Recommendation Report for Planning Permission for Works or Extension to a Dwelling

REF NO: FP/28/20/HH

LOCATION: 23 Middleton Road
Felpham
PO22 6BL

PROPOSAL: Proposed front extension, fence and entrance gates.

Proposed Street Scene

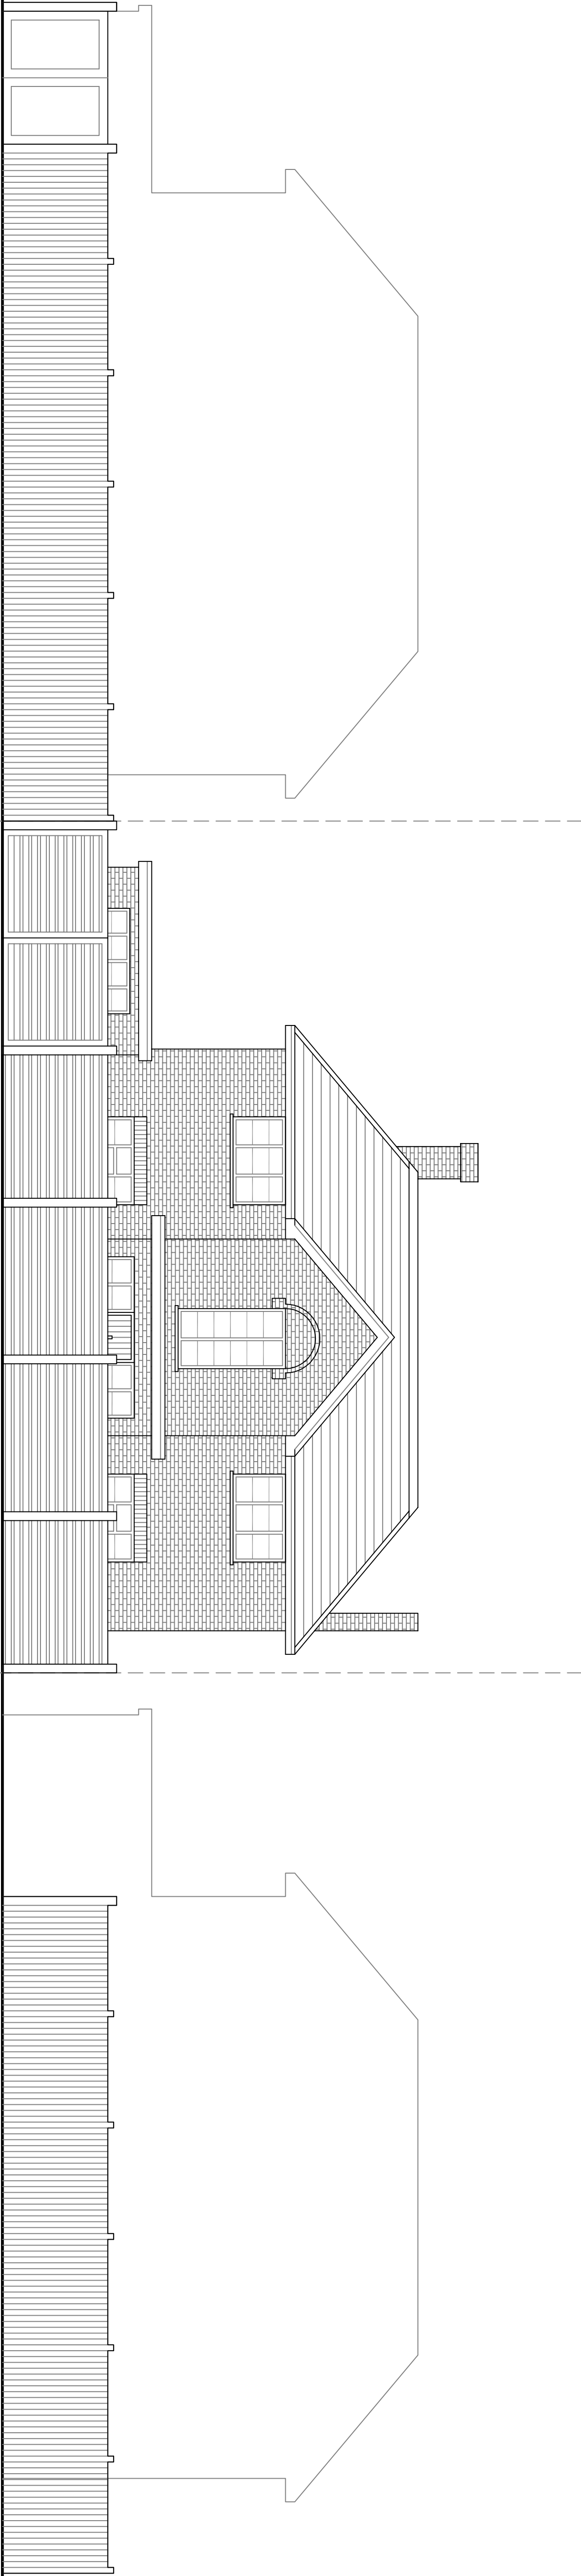
The surrounding properties are similar in style and design however at single storey the proposal is not considered to appear out of character. 14m will be retained to the front boundary which will consist of new fencing and therefore the view is partially restricted.

The proposal will also construct new boundary treatment which will run along the front elevation of the property with a width of around 12m. This will consist of a fence and new entrance gates with height of around 1.4m. The neighbouring properties have similar boundary treatment to a similar height and therefore the proposal is not considered to appear out of character with the area or unduly dominant upon the street scene.

Proposed East Elevation

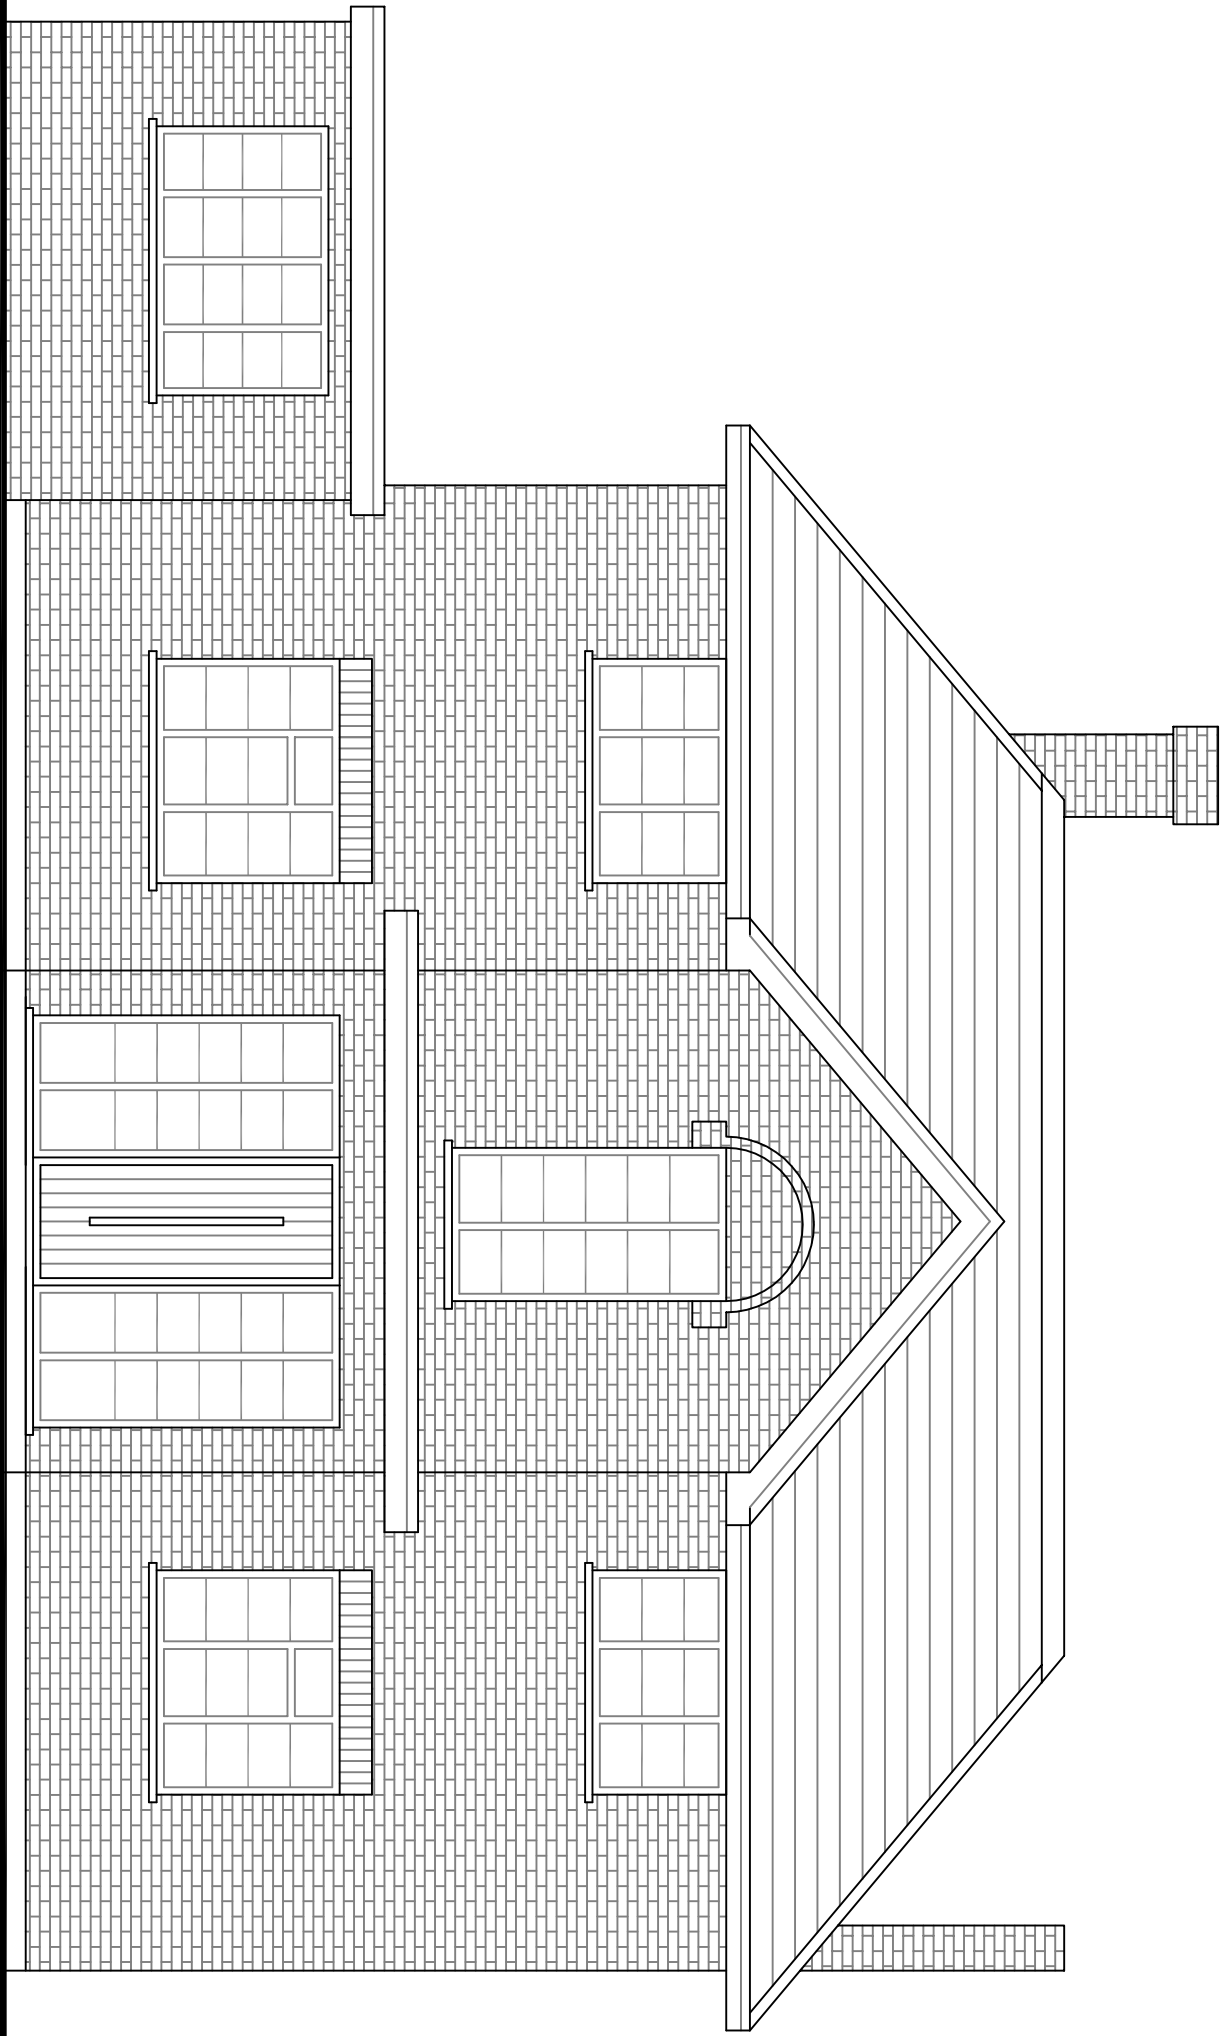
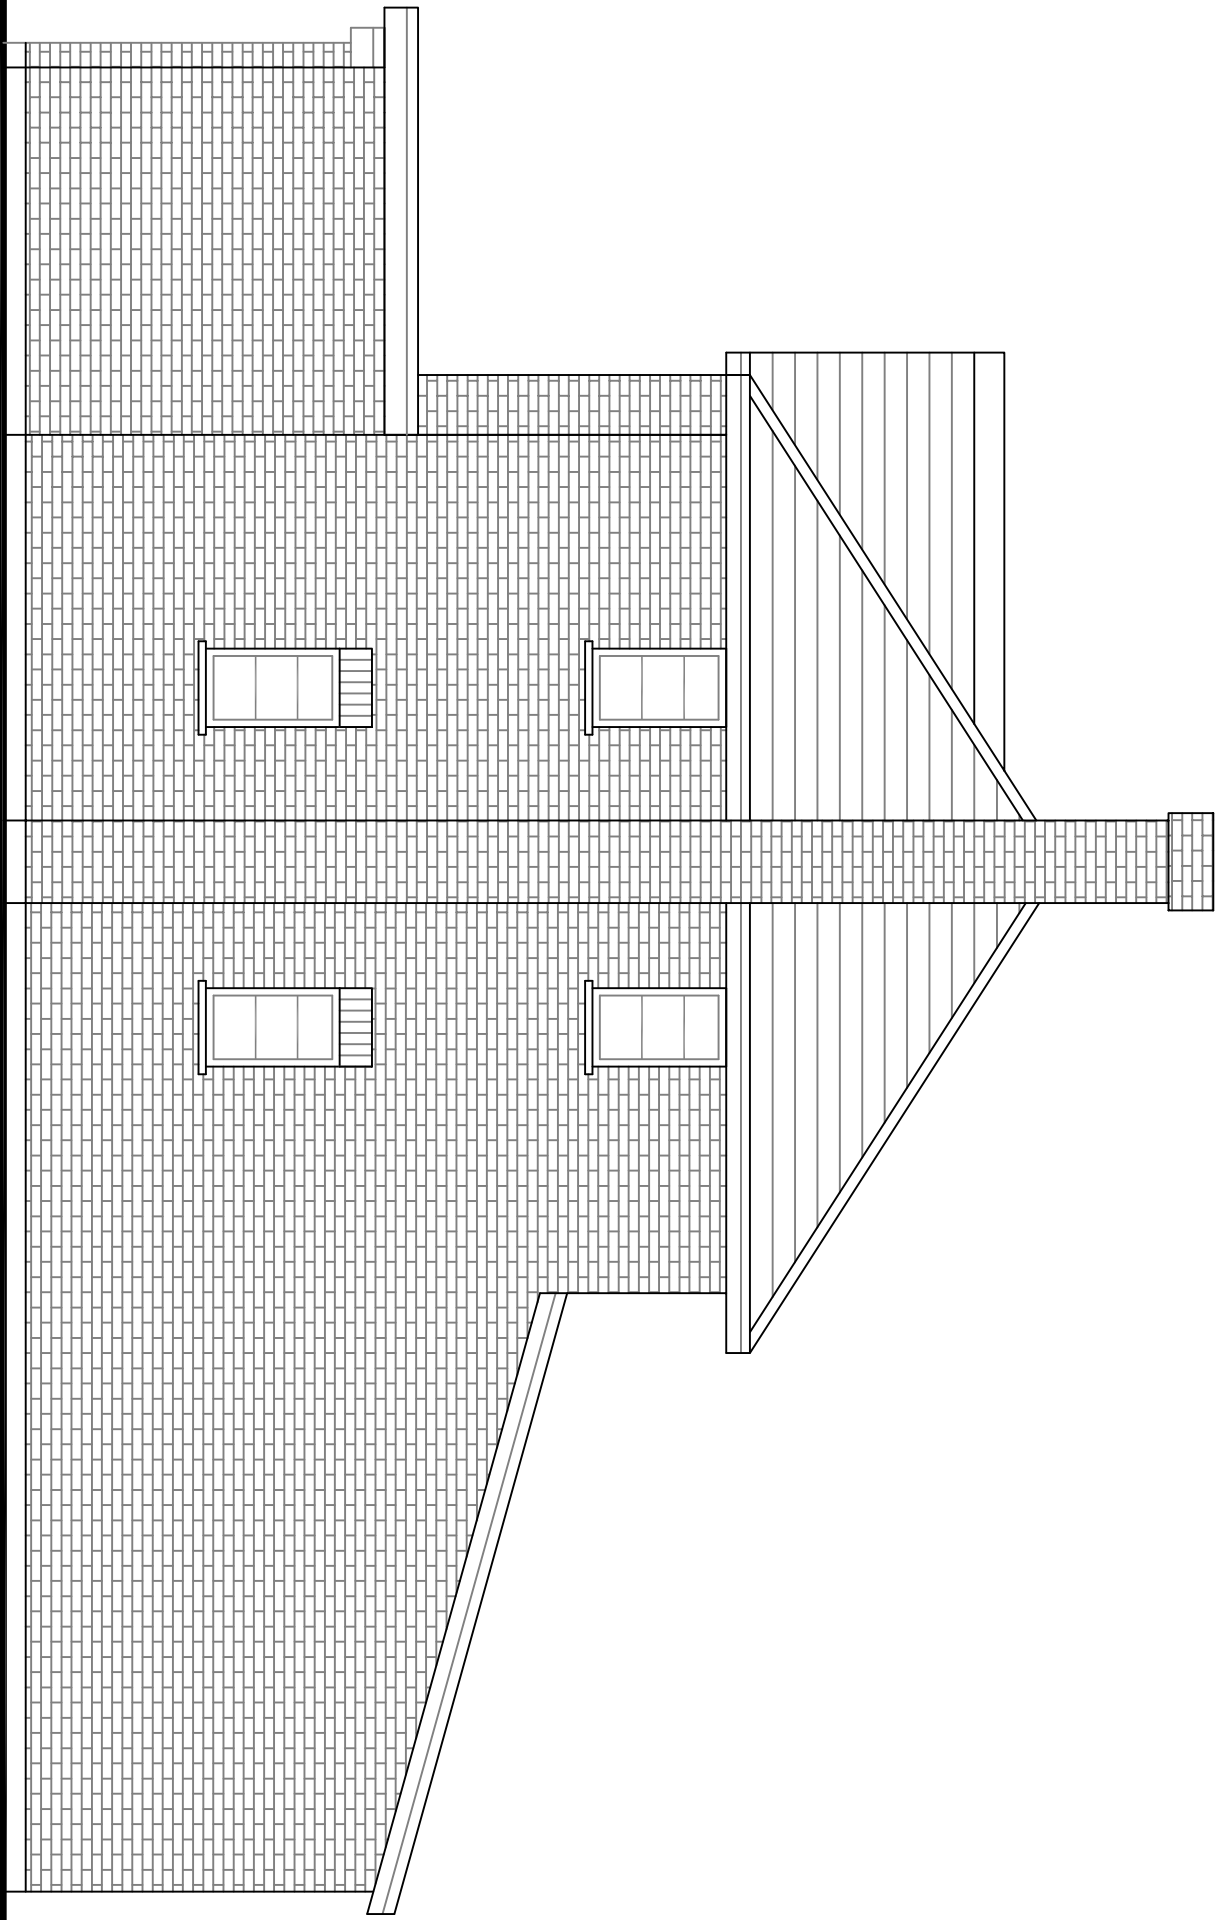
The extension will have a depth of approximately 2.1m and will meet in line with the existing garage.

The front extension will have a depth of approximately 2.1m and a width of 3.3m. It will have a height of 2.85m with a flat roof. The extension retains 5.1m to the eastern elevation which is considered sufficient to ensure the development does not appear overbearing or overshadowing upon neighbouring amenity.

There will be a door to the front, with views over the front garden and street scene and as such is not considered to result in overlooking. As a result of the siting of the new boundary treatment, it is not considered to result in adverse impacts upon amenity.
